KVFR Prevention Short Plat Comments

Project: Willard Short Plat
Permit#: SP-22-00004
Date: 04/28/2022

HAYBROOK FARMS - PHASE 2
 PART OF GOV'T LOT 3, SECTION 30, T. 18 N., R. 19 E., W.M.
 AND OF THE E 1/2 OF SECTION 25, T. 18 N., R. 18 E., W.M.
 KITTITAS COUNTY, WASHINGTON

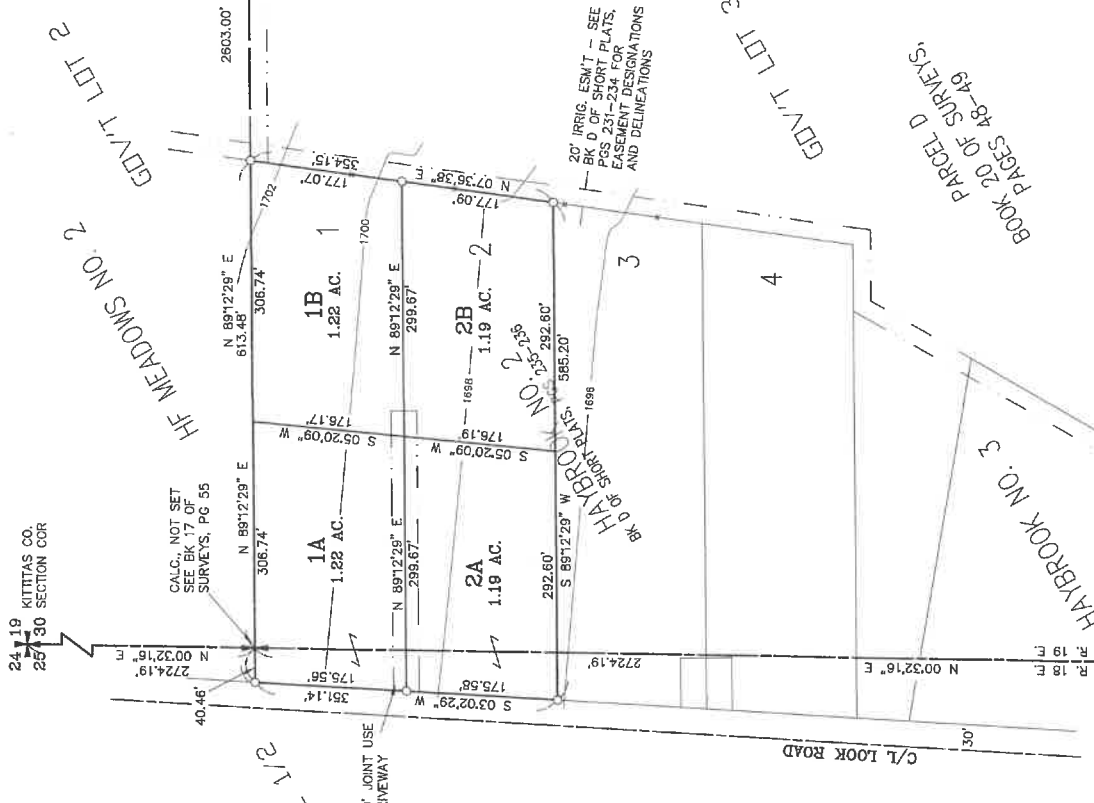
- Fire apparatus access roads exceeding 150' shall be provided with a temporary or permanent turnaround meeting the requirement 2018 IFC Appendix D.
- Fire apparatus access roads shall not exceed 10% in grade. This is especially critical in our valley's climate.
- The IFC Appendix D requires the road be a minimum of 20' wide and capable of supporting an imposed load of at least 75,000 lbs.
- Our standard turning radius is a minimum of 23' inside and 45' outside.
